## WEST SUSSEX COUNTY COUNCIL CONSULTATION

| <b>LOCATION:</b>                | Babsham Business Centre, Babsham Lane, Bersted,<br>PO21 5EL                                                                                                                                    |
| <b>SUBJECT:</b>                 | BE/89/19/PL<br><br>The change of use of land for the storage of building materials, equipment & plant & for the parking of 2no. articulated vehicles together with part boundary screen fence. |
| <b>RECOMMENDATION:</b>          | More Information                                                                                                                                                                               |

PROPOSED SITE PLAN - 1:200

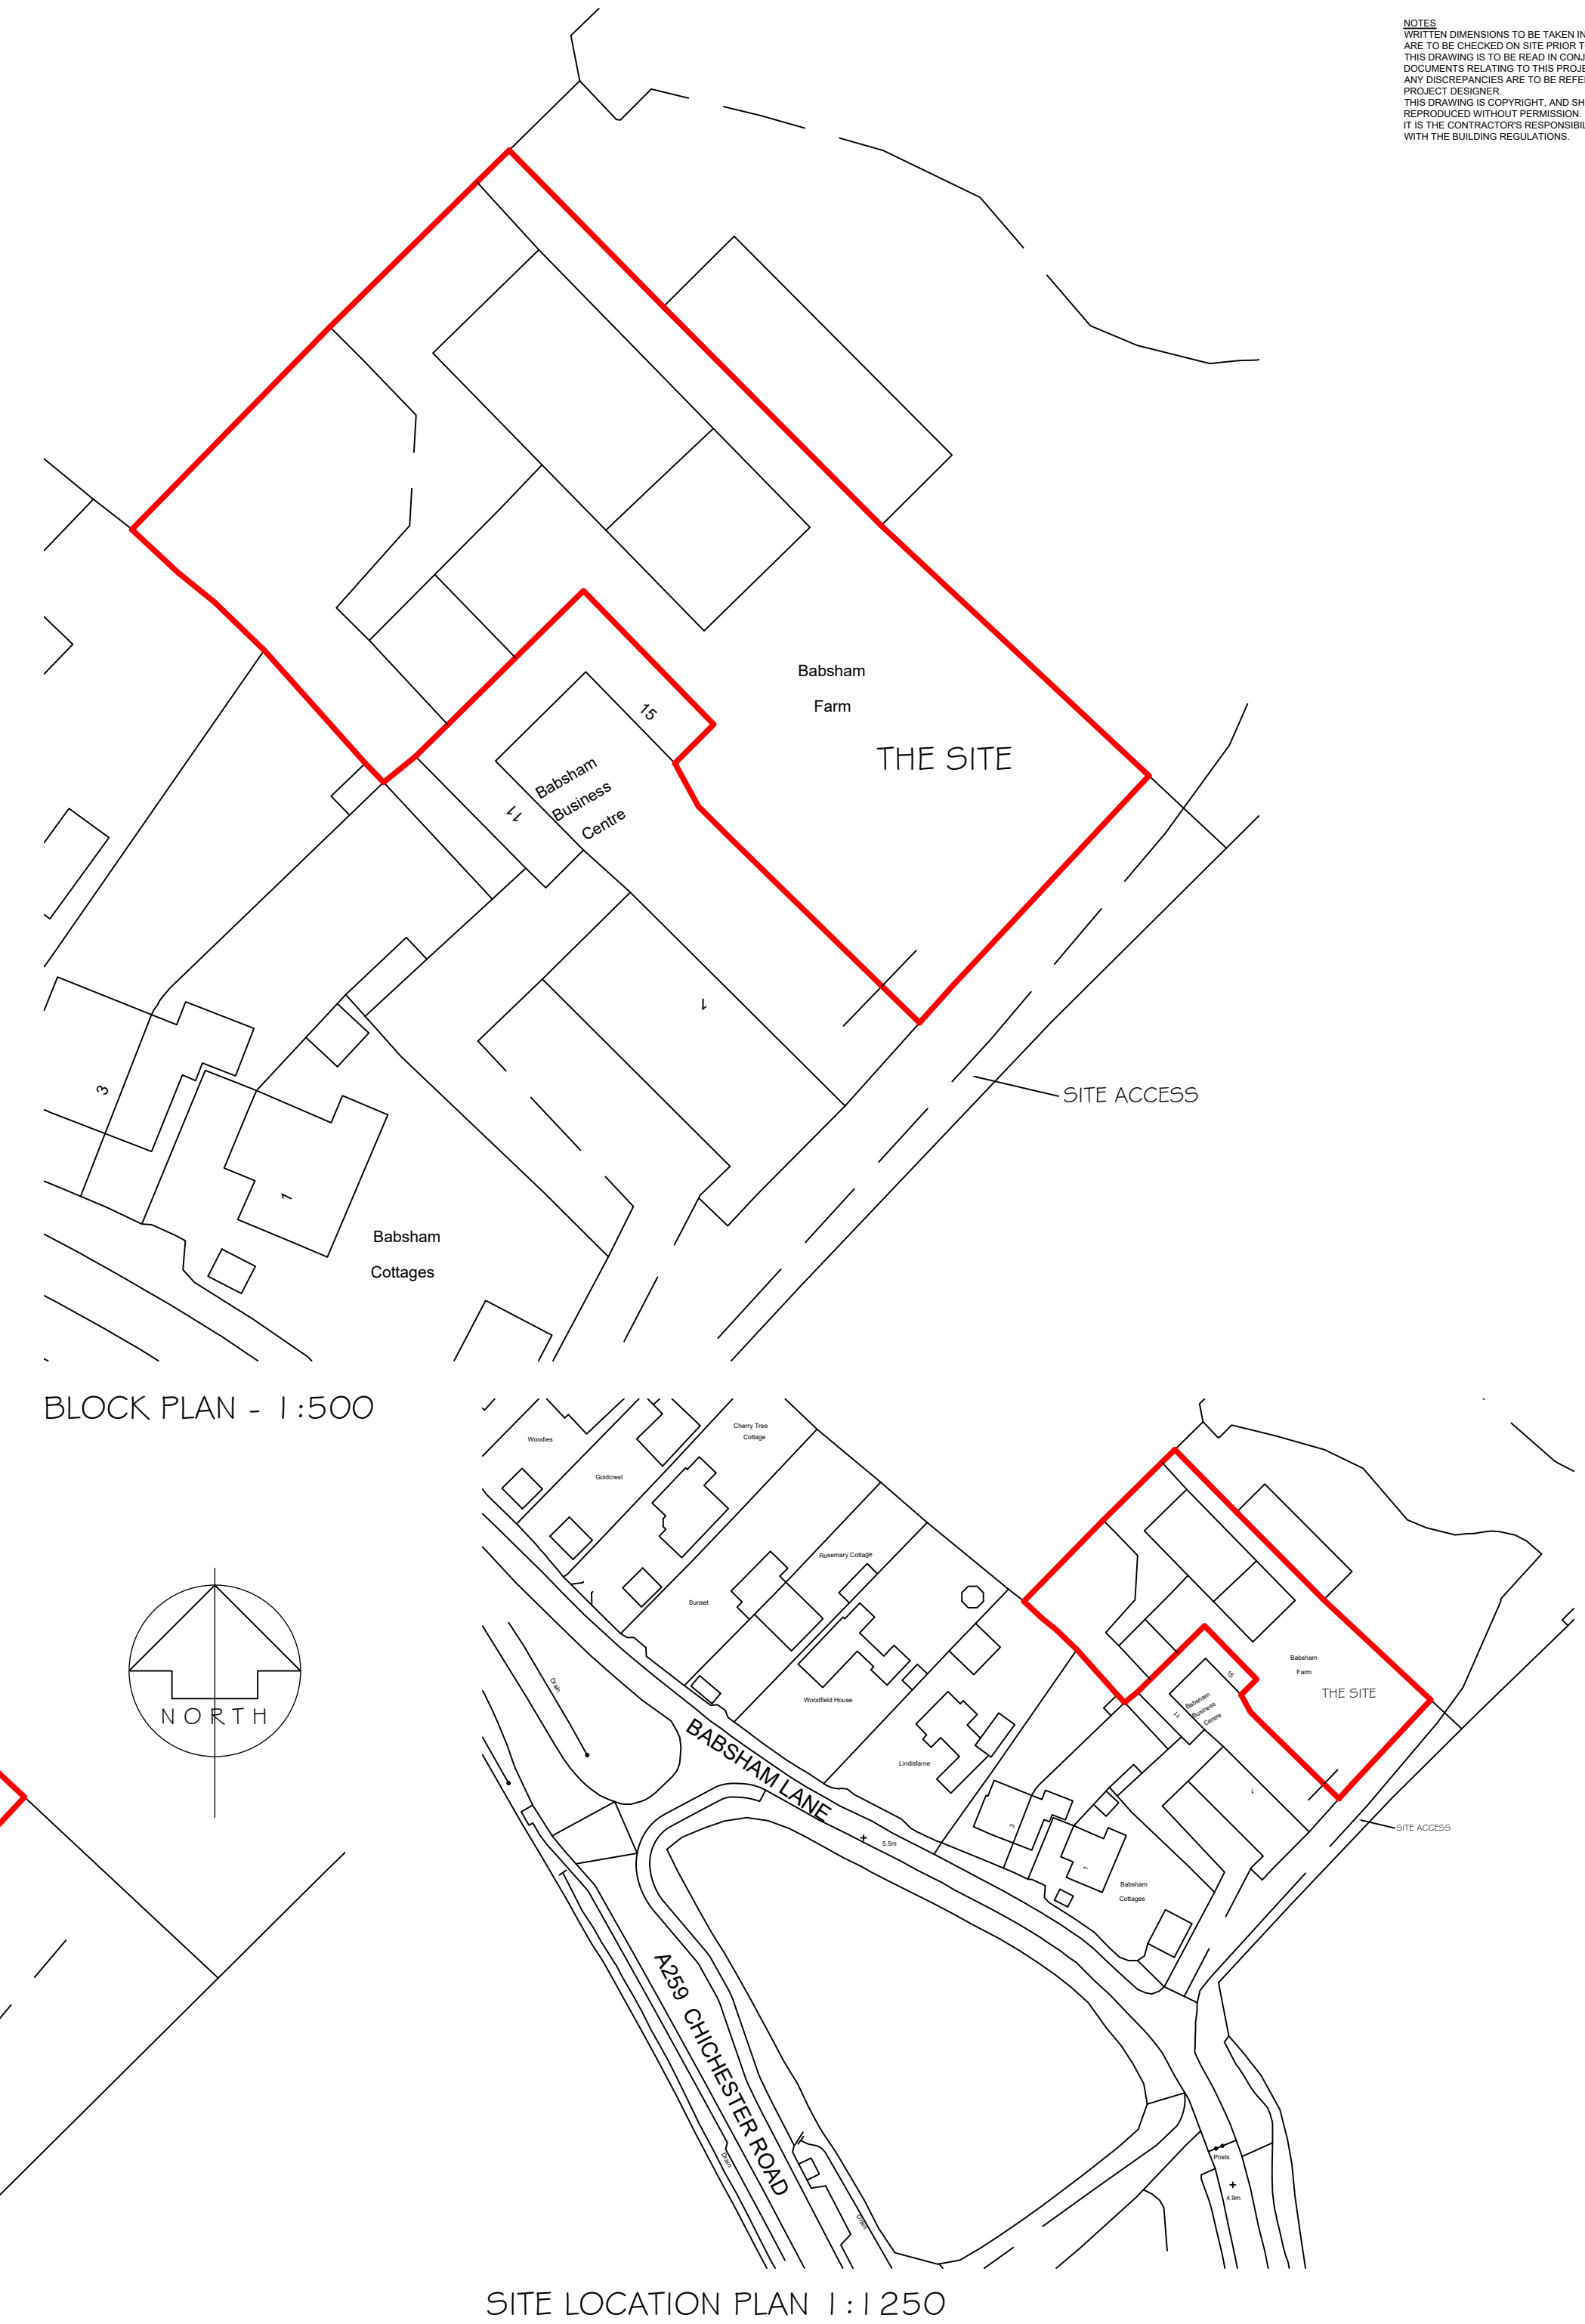
The proposed 2.4m fencing is sited within private land and does not encroach on any highway boundary and does not obstruct vehicular visibility. No employees will be directly employed at the site. The proposed plan indicates that a designated parking area for two articulated lorries will be provided on site. There appears to be sufficient space within the proposed lorry parking area for two articulated vehicles to be accommodated.

The applicant has referenced that gates will be erected on the access track to improve security. No details of the proposed gates have been provided. The applicant is requested to demonstrate the location of the proposed gates on the plan, including details of how and when these will be in operation, and any necessary measures that will be taken to avoid vehicle conflict and queuing on the public highway.

The applicant has not demonstrated how articulated vehicles are currently turning on site. The applicant is requested to provide details of this, and if necessary, should demonstrate with swept path analysis that the proposed positioning of the gates will not impact upon the ability for articulated vehicles to turn on site.
